<b>Late Items – Planning &amp; Development Committee</b>				 Ribble Valley Borough Council <a href="http://www.ribblevalley.gov.uk">www.ribblevalley.gov.uk</a>
<b>Meeting Date: 5 FEBRUARY 2026</b>				
<b>Briefing version</b>		<b>Issue Date:</b>		
<b>Committee Version</b>	•	<b>Issue Date:</b>	05/02/2026	
<b>Application Ref:</b>	3/2025/0588	<b>Land East of Clitheroe Road, Whalley</b>	<b>REC:</b>	<b>REFUSAL</b>

Since the agenda was published officers wish to provide the following points of clarification as well as an update to the drafting of refusal reason #2 (splitting this into two separate reasons): -

Figure 2: Nighttime L_{Amax,F,1s} readings [free-field]

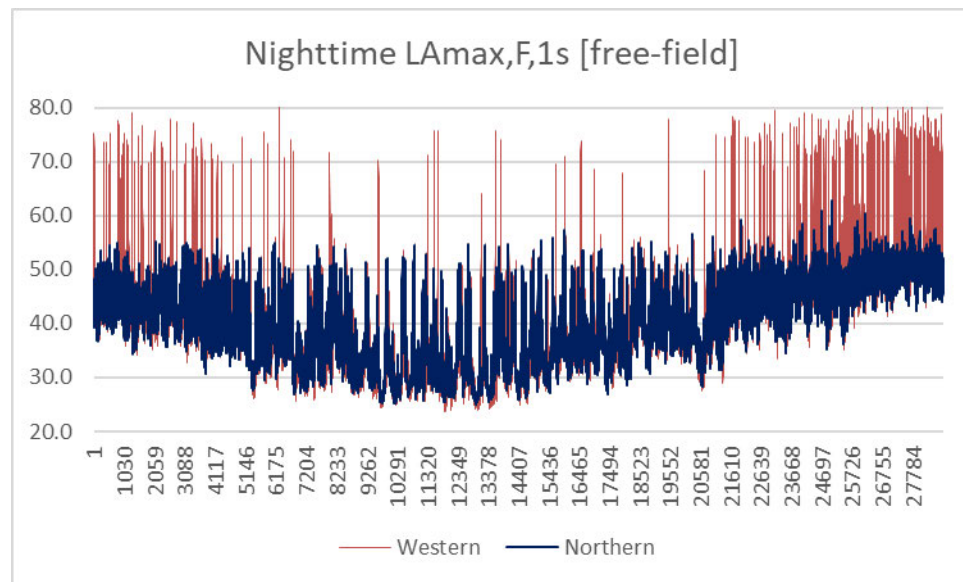
*Specifically, BS8233:2014 mentions L<sub>Amax</sub> only in general terms for sleep disturbance but gives no numeric L<sub>Amax</sub> criterion. No UK document (BS8233, BS4142, ProPG, NPSE, NPPF) sets a "10th highest" rule.....The WHO guidelines themselves do not specify using the 10th highest L<sub>Amax</sub> event it states levels of an L<sub>Amax</sub> of 45dB shall not be exceeded 10-15 times a night. We would expect the report to use the highest L<sub>Amax</sub> levels in evaluating the findings, to ensure the mitigation is sufficient to protect amenity of future residents indoors.*

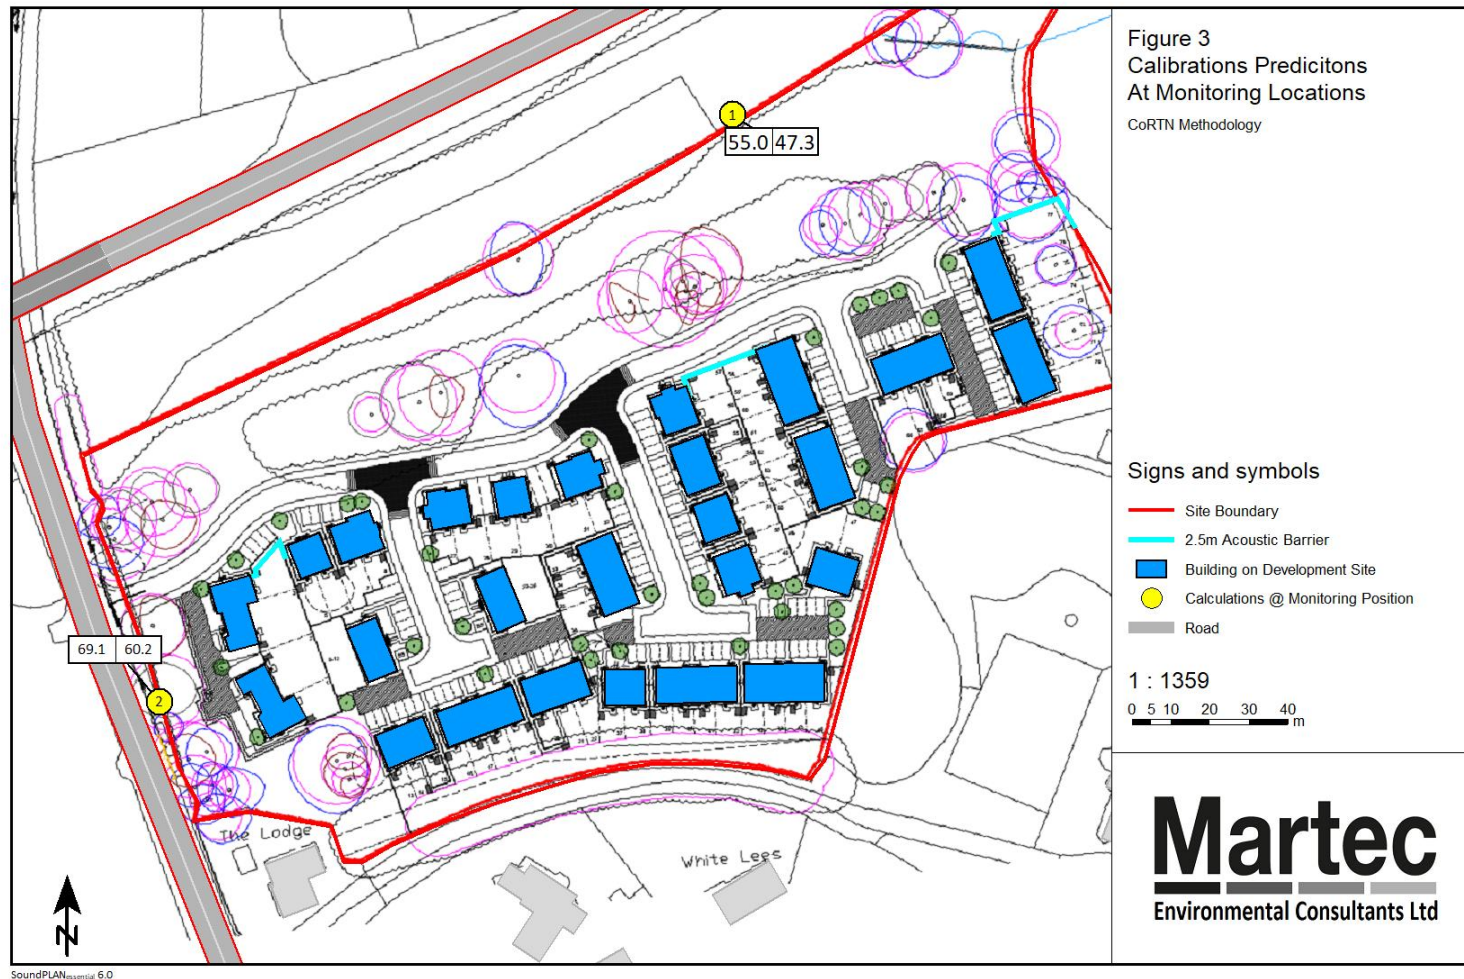
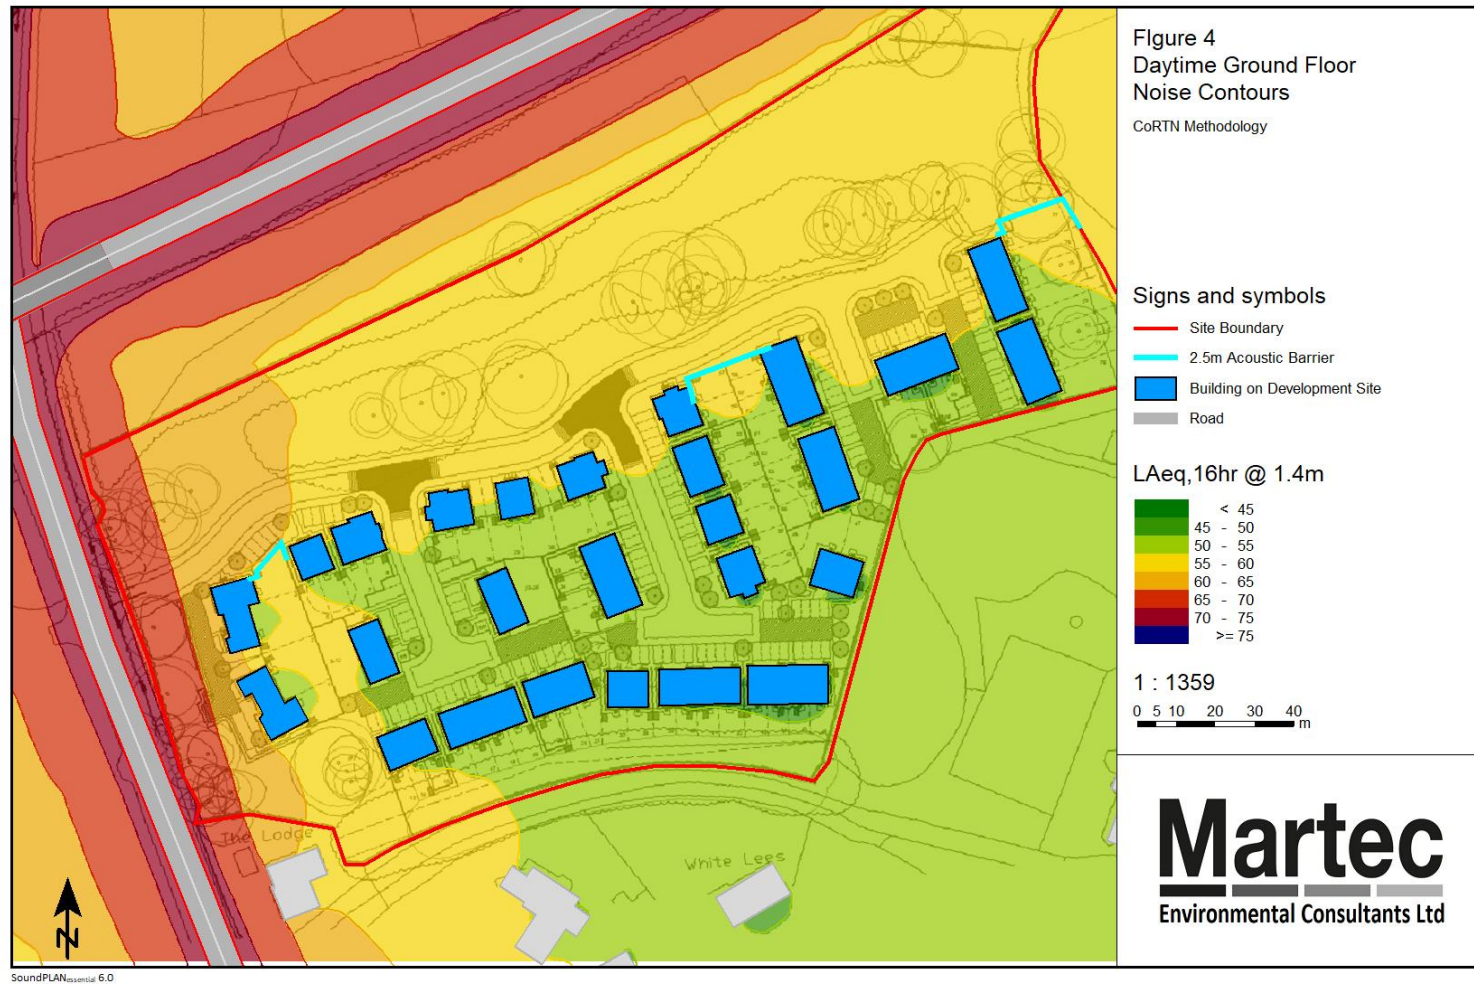
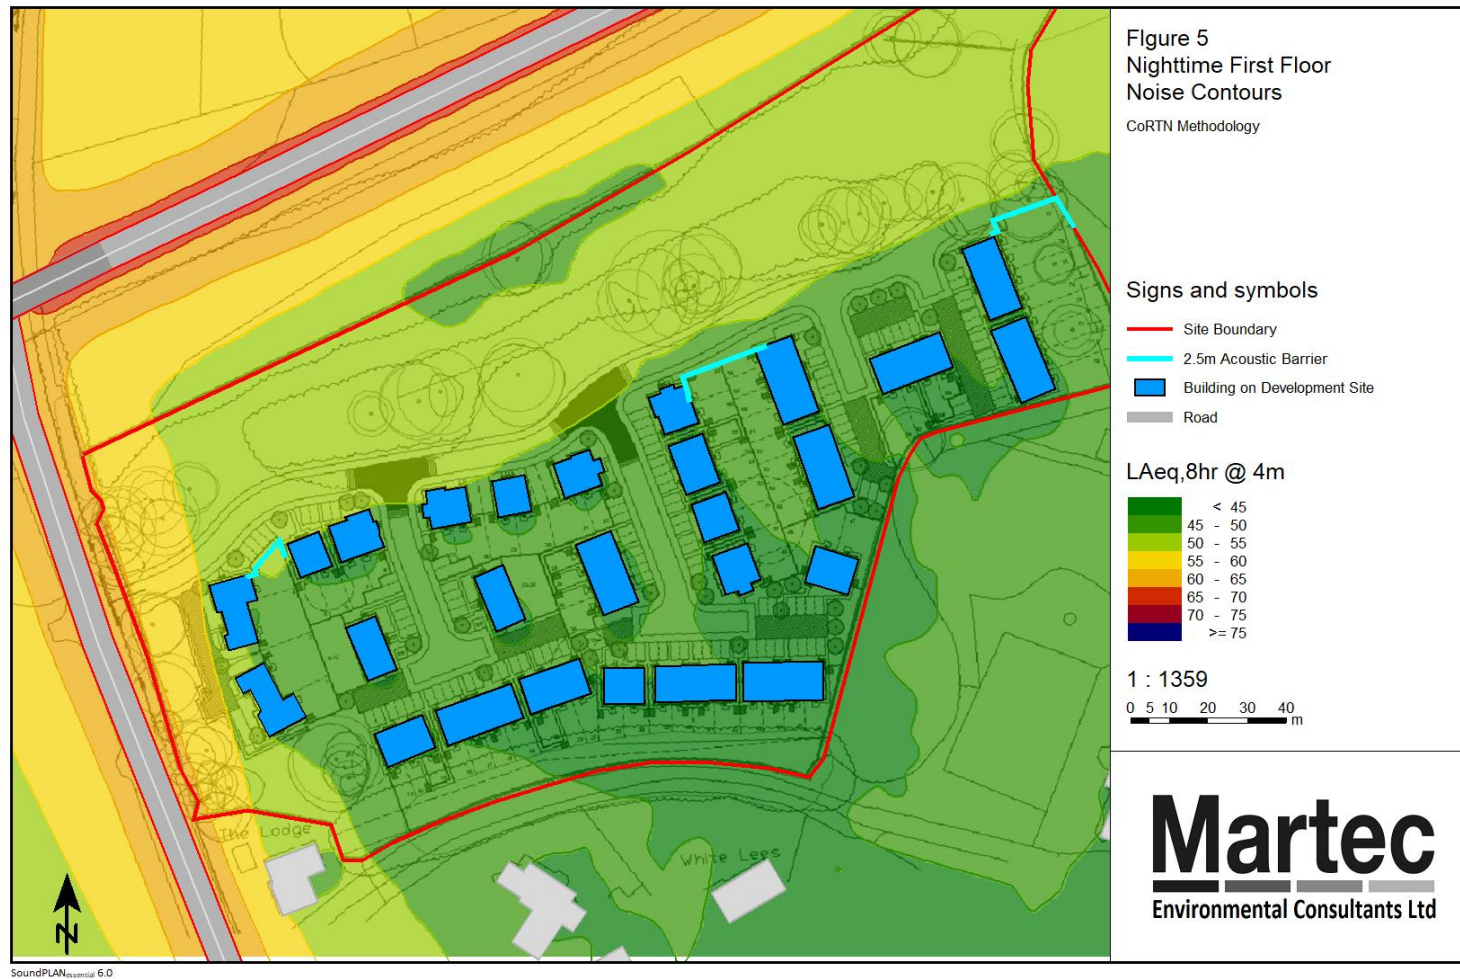
*Figure 4 of the WHO guidelines state that to avoid serious annoyance in an outdoor living area L<sub>Aeq</sub> levels shall not exceed 55dB for moderate annoyance 50dB some of the outdoor areas are exposed to 55-60dB, [and] levels will likely be higher during the day as traffic increases.*

*[Furthermore] the report submitted has errors in it regarding the noise modelling; plan, [but] this has not been revised.*
